**DEVELOPMENT UNDER SECTION 182A(1)
(ELECTRICITY TRANSMISSION LINES) OF
PLANNING & DEVELOPMENT ACT 2000 –
2023**

**MEATH COUNTY COUNCIL
PLANNING SUBMISSION REPORT**

ACP-323456-25

Development Description: 110kV/20MW Distribution
Substation.

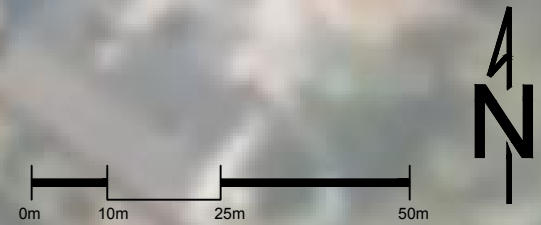
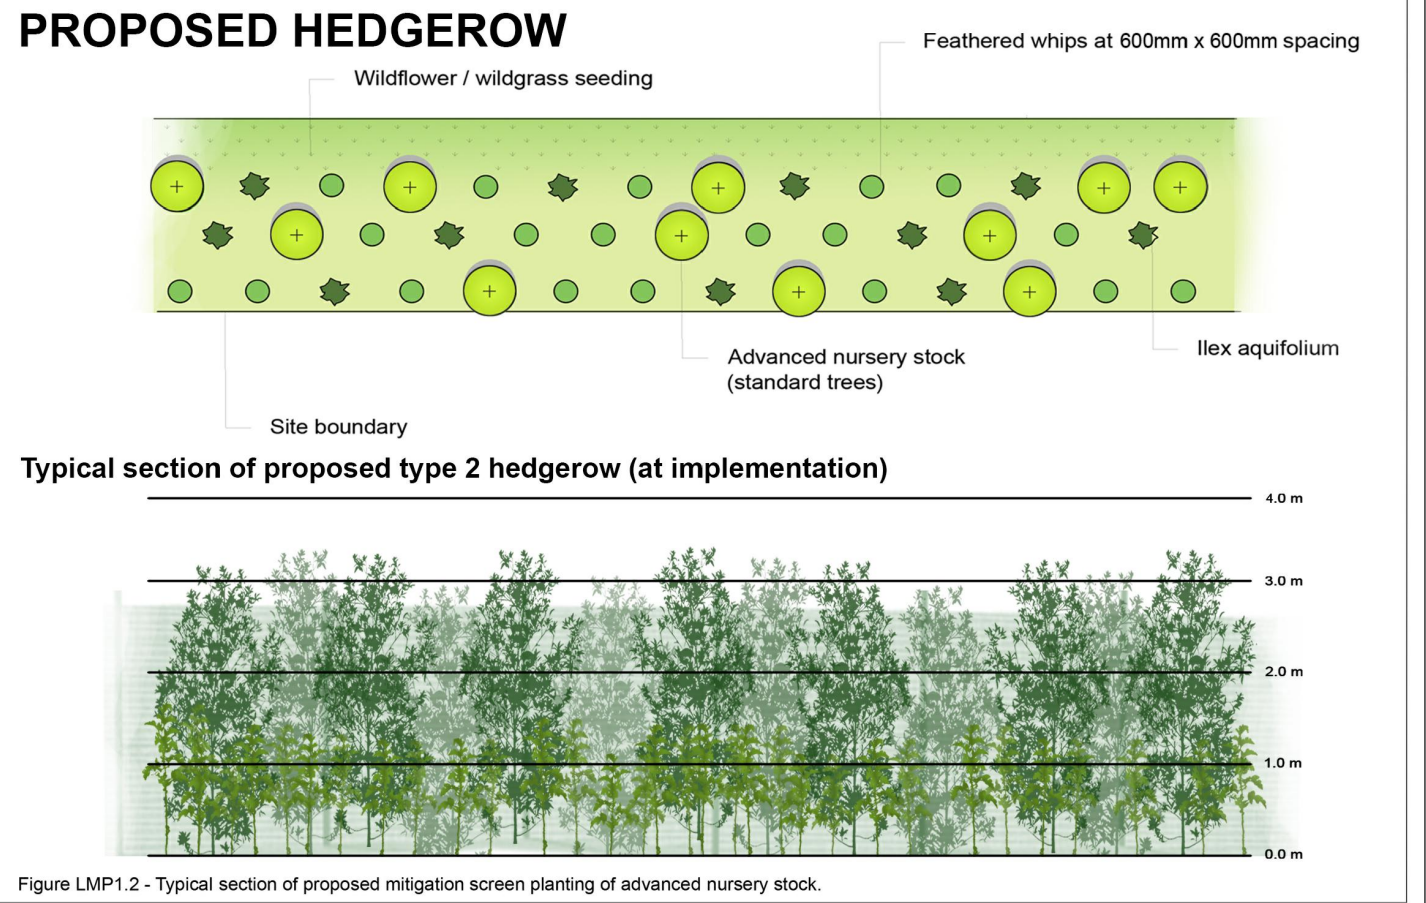
4. *Prior to the commencement of any of the proposed development, the applicant shall submit a revised landscape plan to cooperate with the proposed riparian zone.*
